**RE: 6/2020/0736/COND – Northaw House, Coopers Lane, Northaw, Potters Bar, EN6 4NG**

Thank you for consulting us on the above application for the submission of details pursuant to condition 1 (surface water drainage scheme) and 5 (arboricultural method statement) on planning permission 6/2019/0217/MAJ at Northaw House, Coopers Lane, Northaw, Potters Bar, EN6 4NG.

We advise the LPA that the information submitted in support of condition 1 in relation to surface water does not comply with the requirements of the condition. Therefore, we recommend that the LPA do not discharge condition 1.

| DRAWING TITLE: | PROPOSED DRAINAGE DETAILS | | |

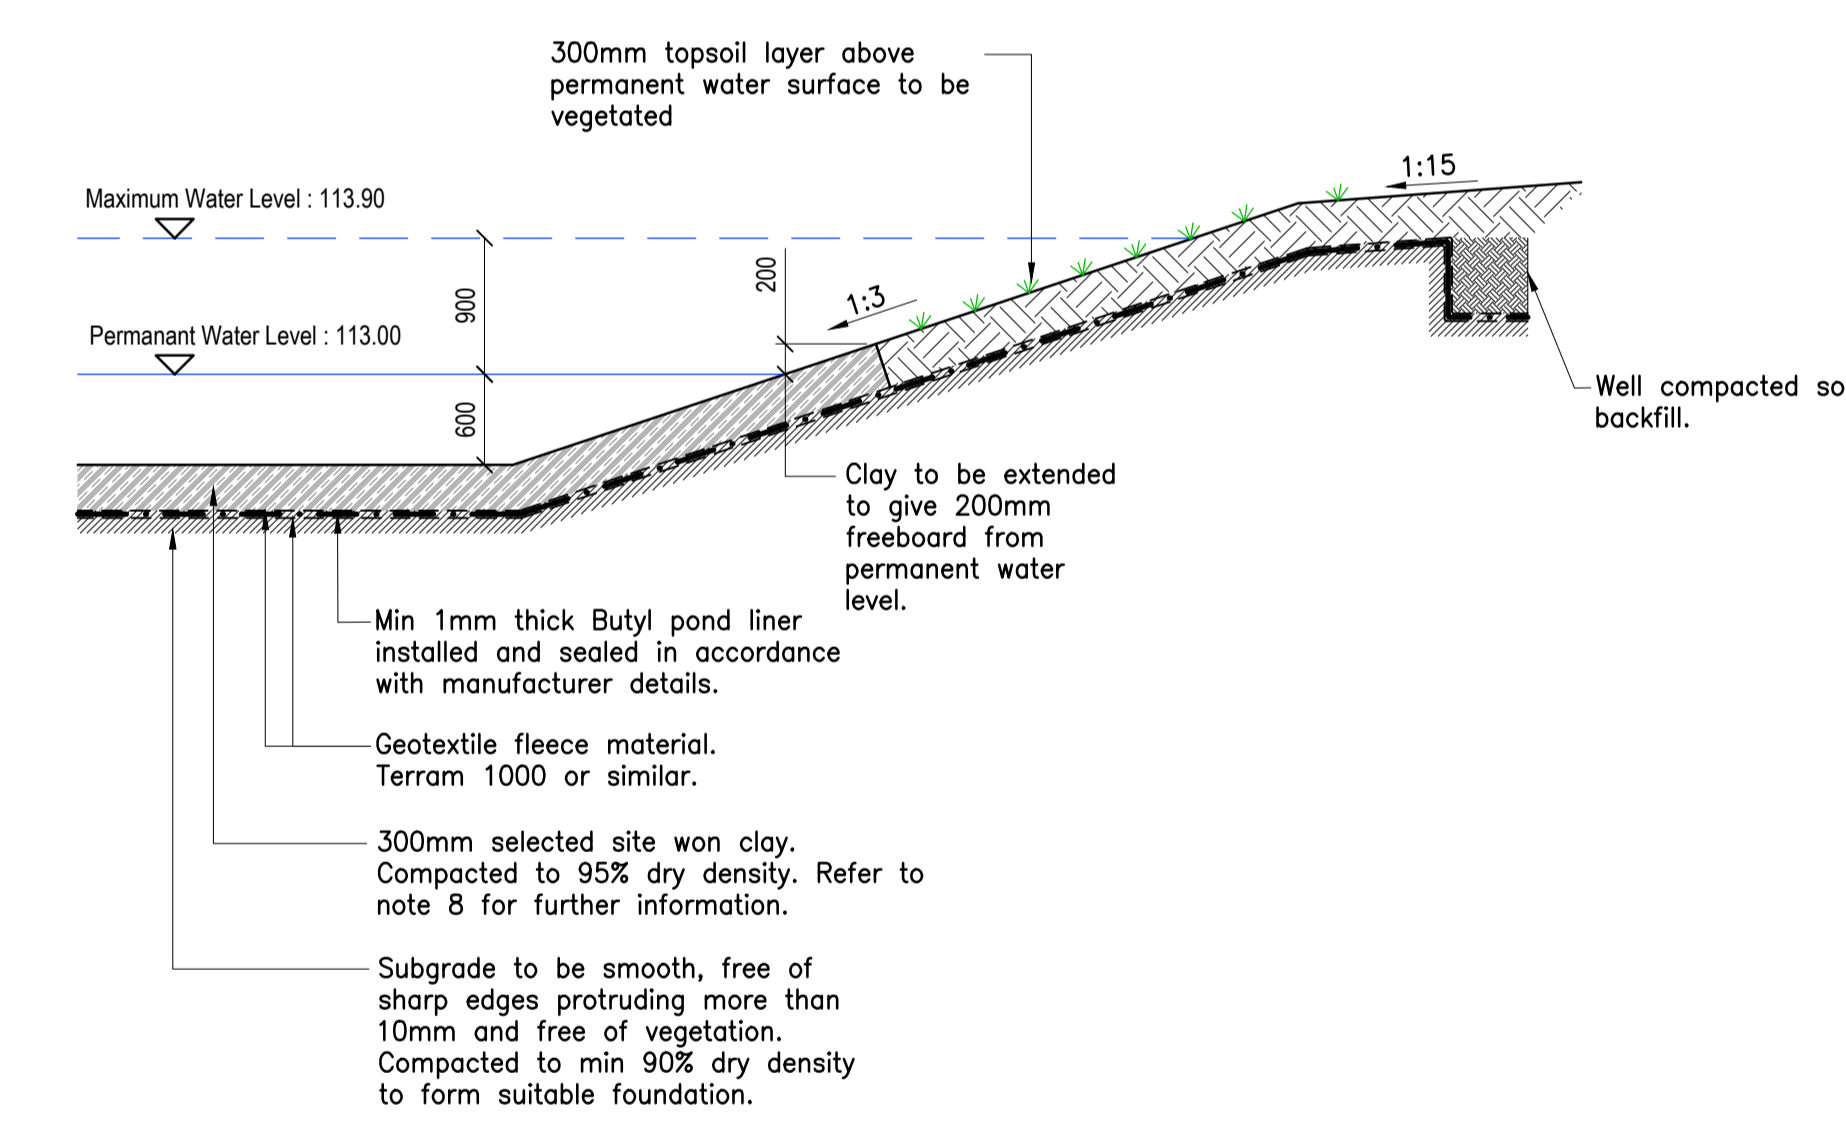
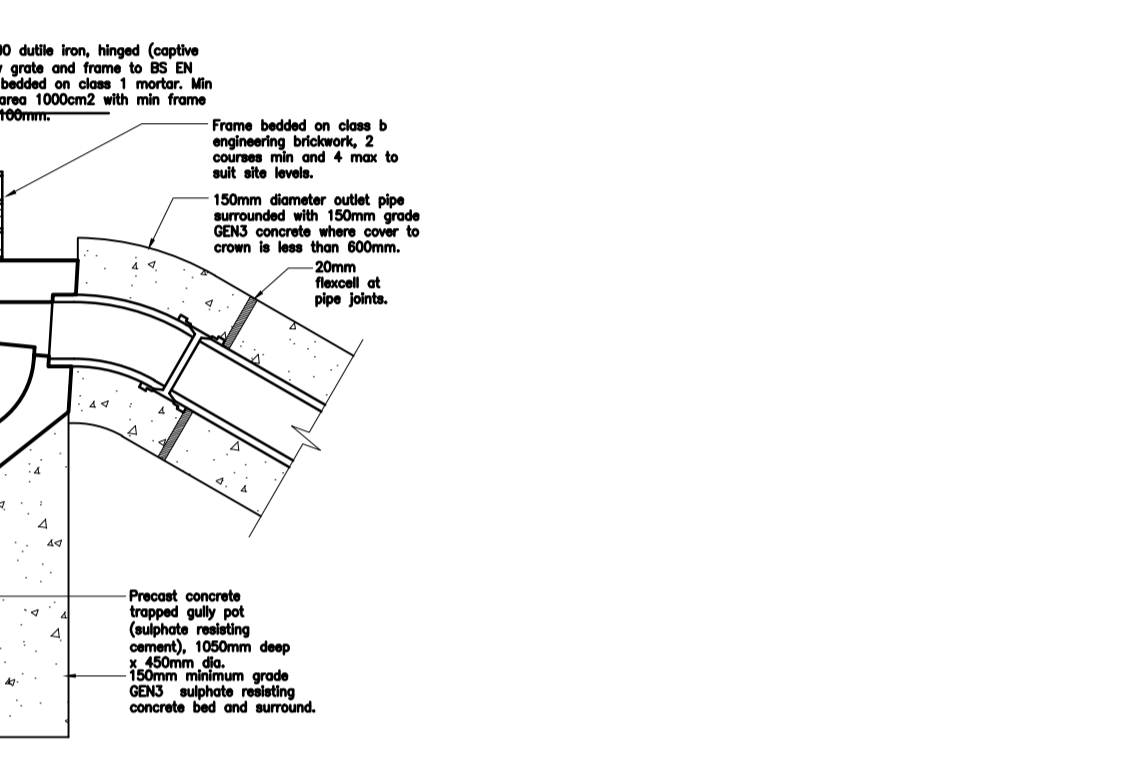
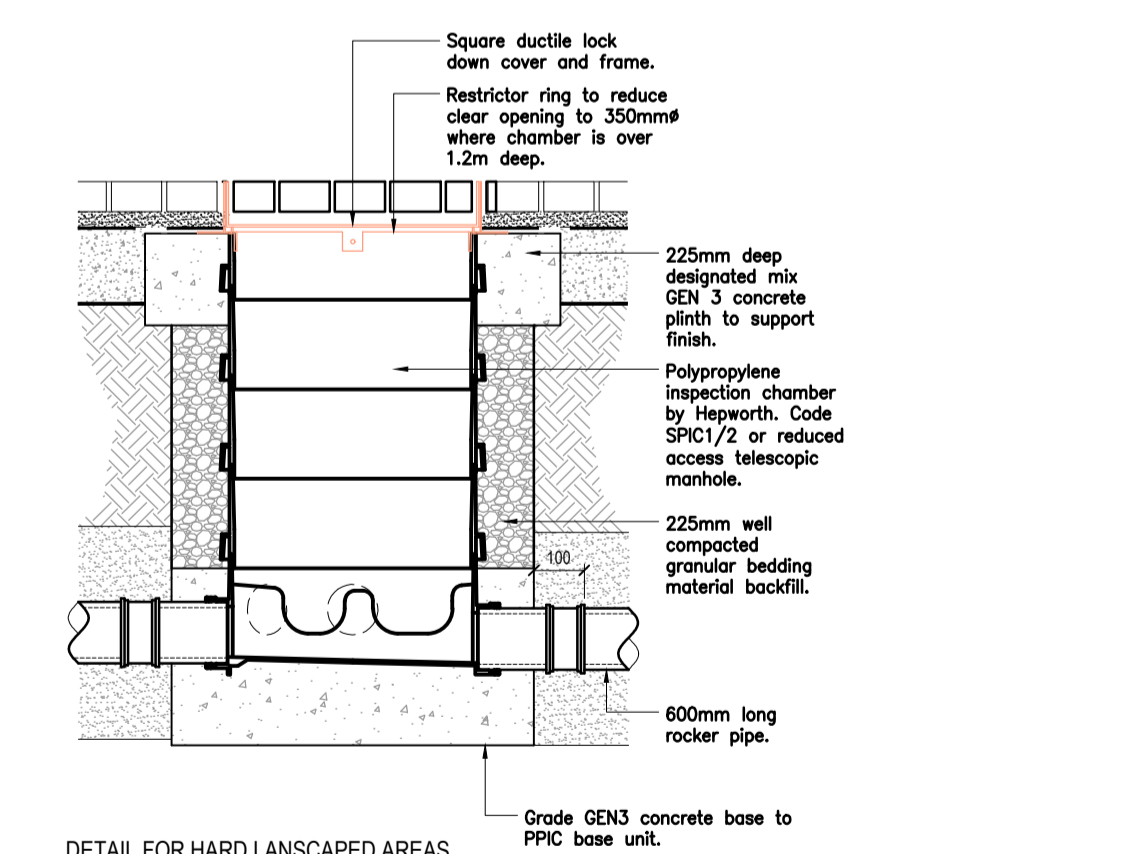
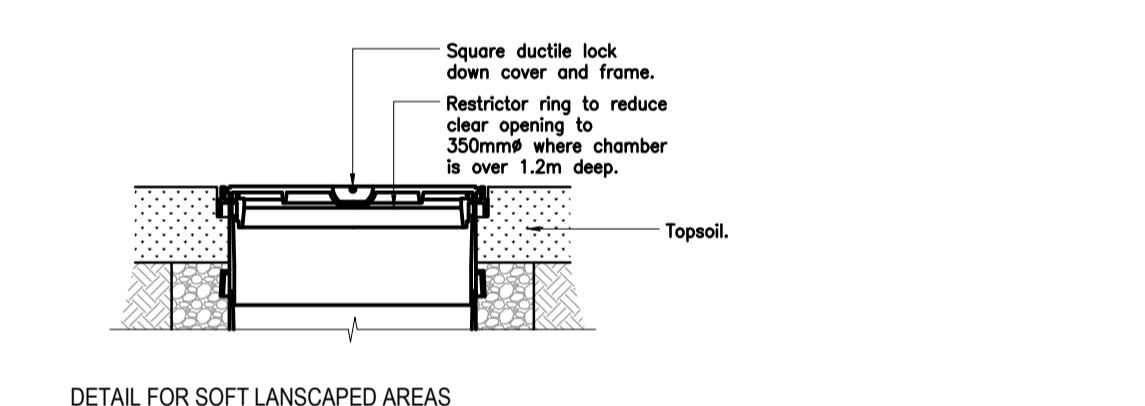
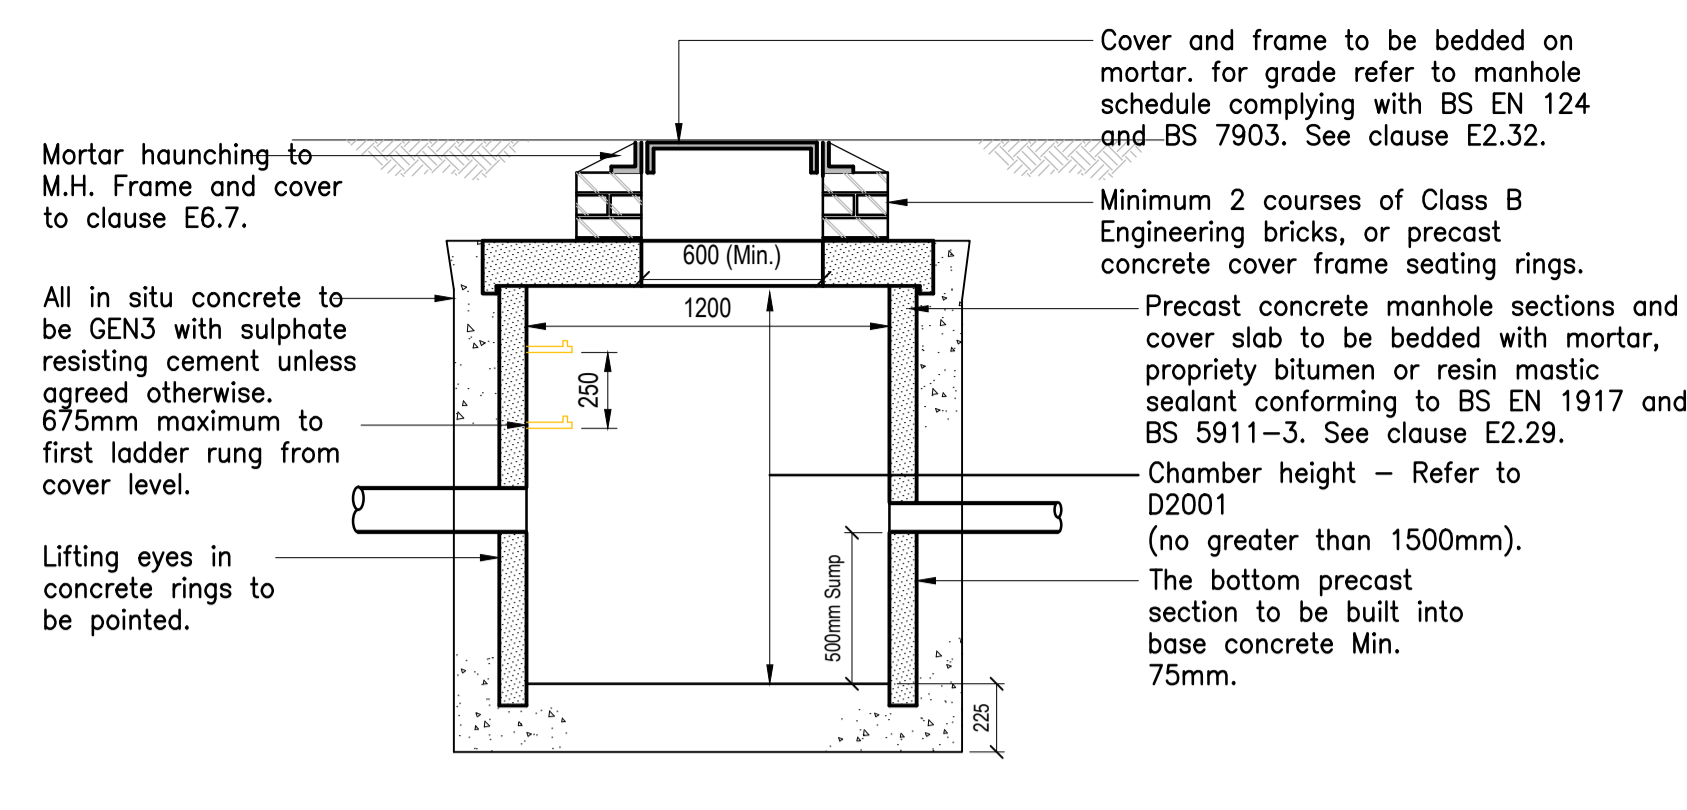
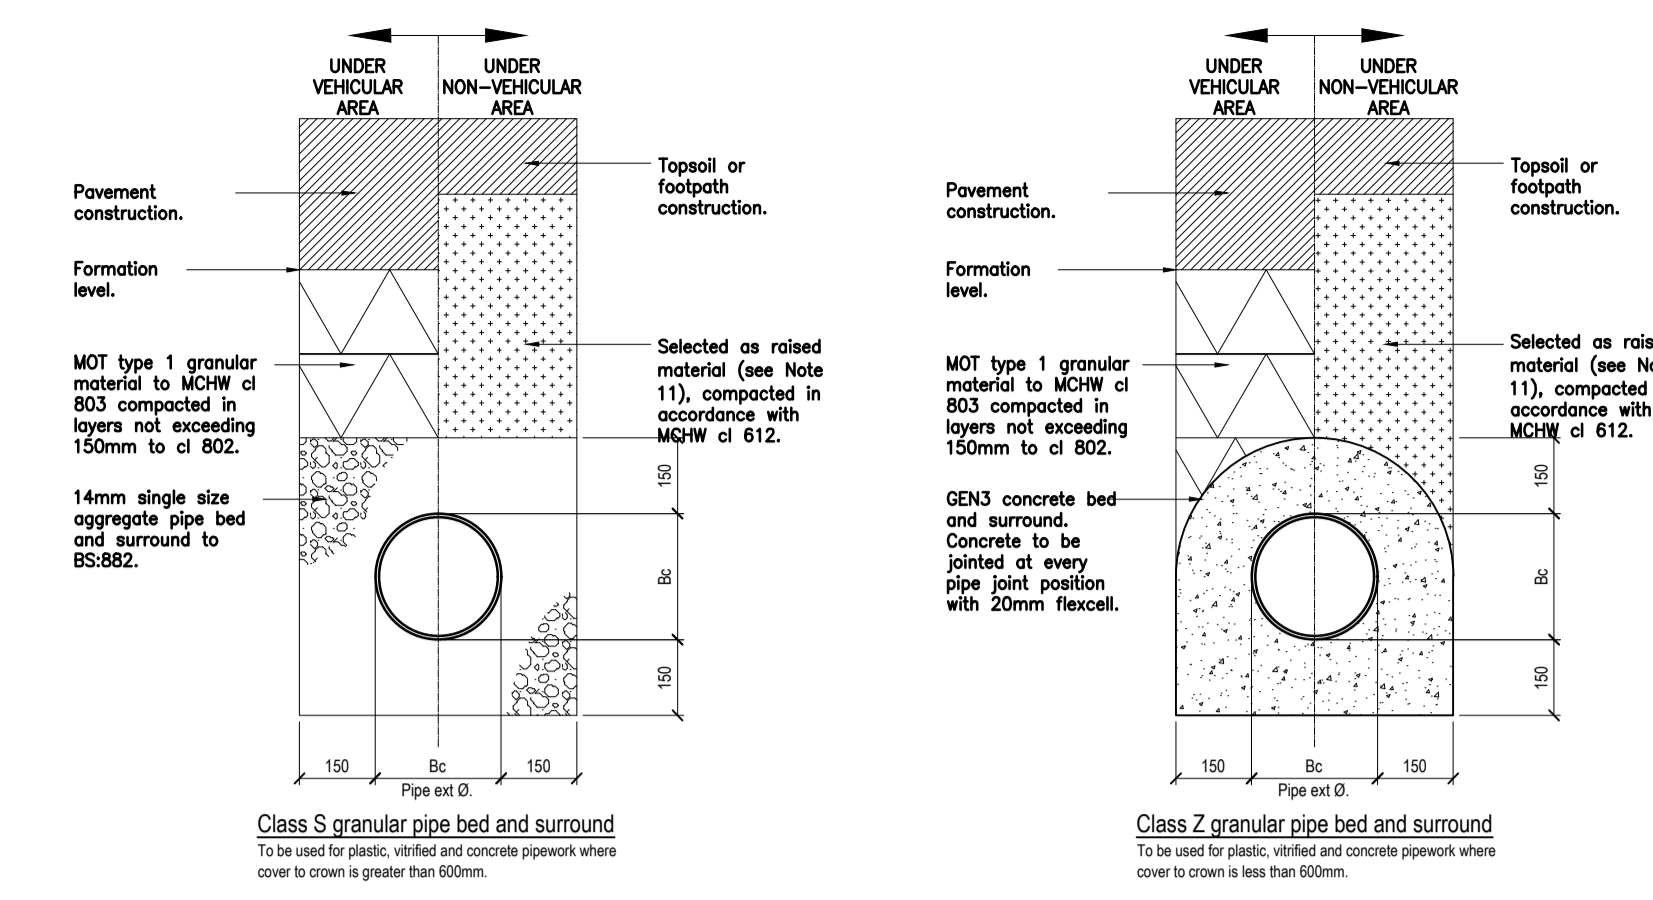
We acknowledge the applicant has submitted the proposed drainage details drawing with indicated typical dry swale details, typical pond and other structures. We note as well, that detailed cross sections of the proposed pond have been submitted. However, inlet or outlet features have not been included.
